Application by Tritax Symmetry (Hinckley) Limited for an Order Granting Development Consent for the Hinckley National Rail Freight Interchange – Deadline 6 submission

Hinckley National Rail Freight Interchange

Leicestershire County Council Design Review Comments as presented to the Applicant team on 14.02.2024 and as discussed at a meeting with the Applicant team on 15.02.2024

Drawn:	J.Manifold	Reviewed:	S.Carter
BWB Ref:	NTT2814	Date:	07.12.23
Scale@A1:	1:500	Status:	PRELIMINARY
Project - Originator - Zone - Level - Type - Role - Number	HRF-BWB-HGN-HW09-DR-CH-0100	Status	S2
Rev	P02

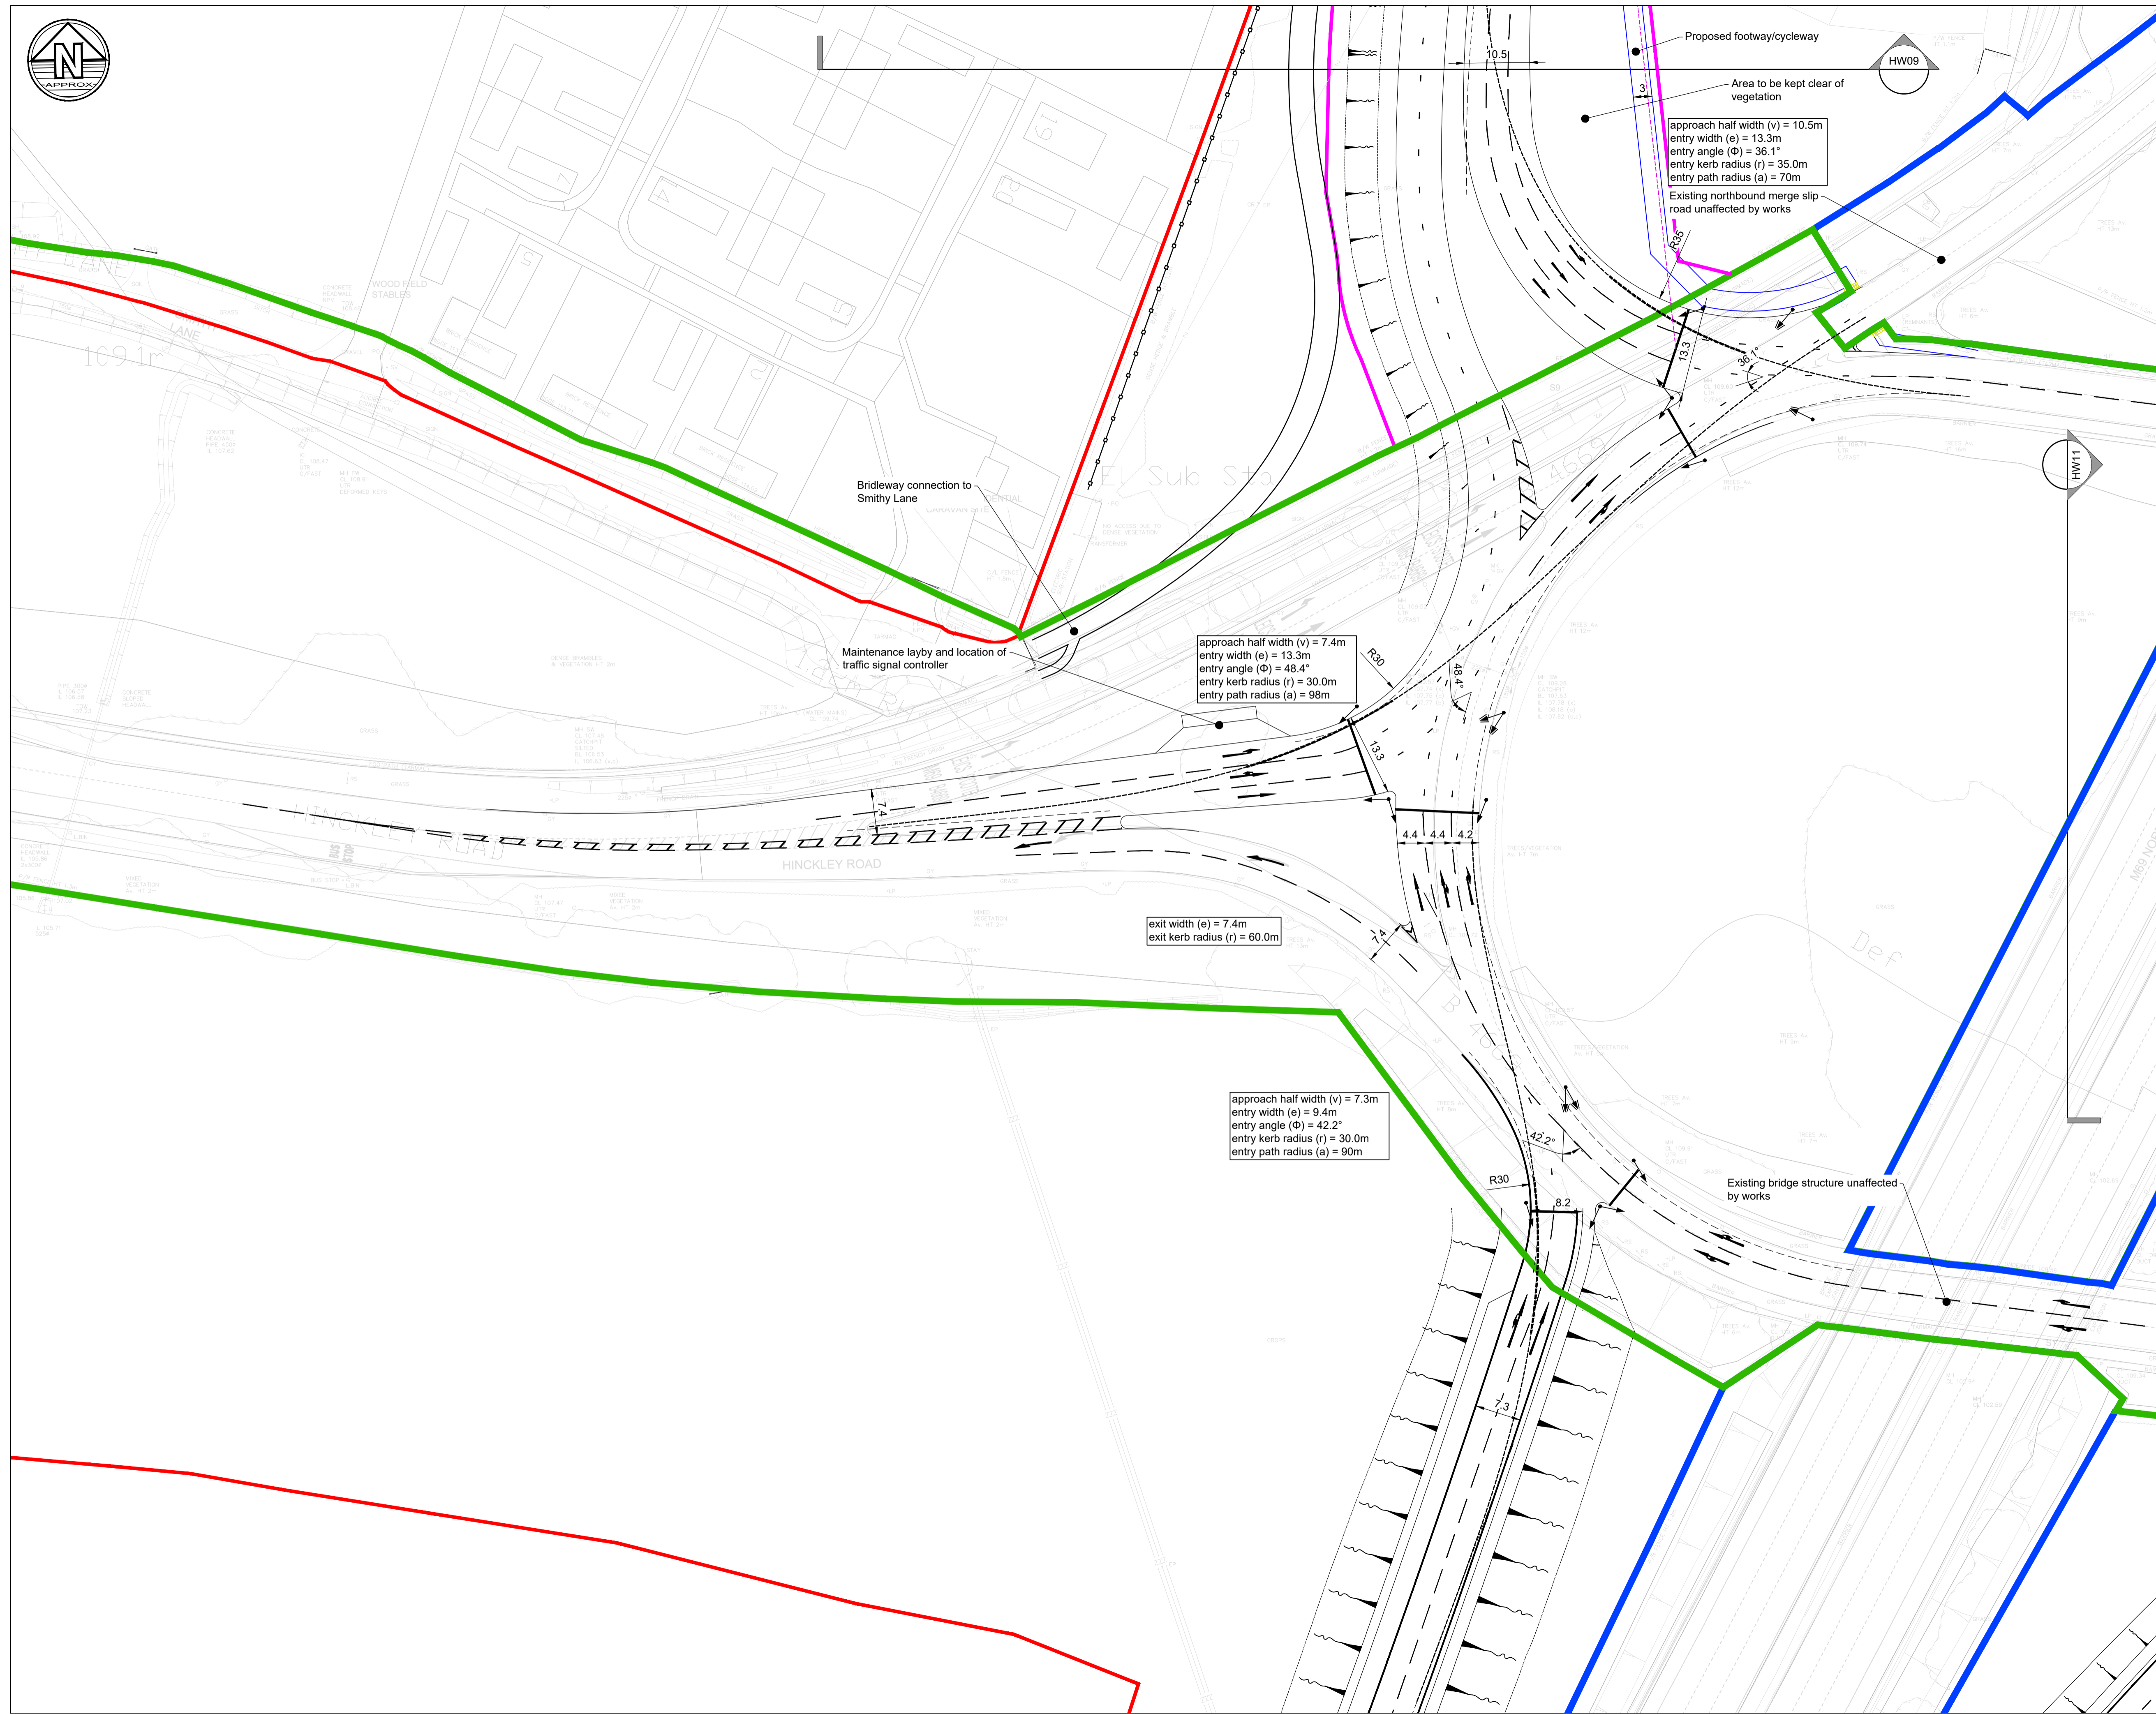
- 2.9.1 Proposal for diverted water course results in an excessive length of culvert. Alternative proposals for this should be considered.
- 2.9.2 Roundabout provision on this drawing is only to facilitate sharp deviation in route, and this two-arm roundabout serves no purpose other than to avoid the need for a tight bend on the main alignment. There is no future development access provided for. CD116 guidance requires a roundabout should have 3 or more arms. Alternatives to this proposal that avoid unnecessary roundabout provision would need to be considered at this location.

- 2.9.3 Forward visibility to roundabout give-way lines need to be indicated on drawing.
- 2.9.4 Concern regarding shared footway/cycleway provision adjacent to embankments and retaining provision. Fencing to protect against falls required.

- 2.9.8 Potential issue with visibility to the proposed Pegasus crossing as you exit the roundabout southbound.
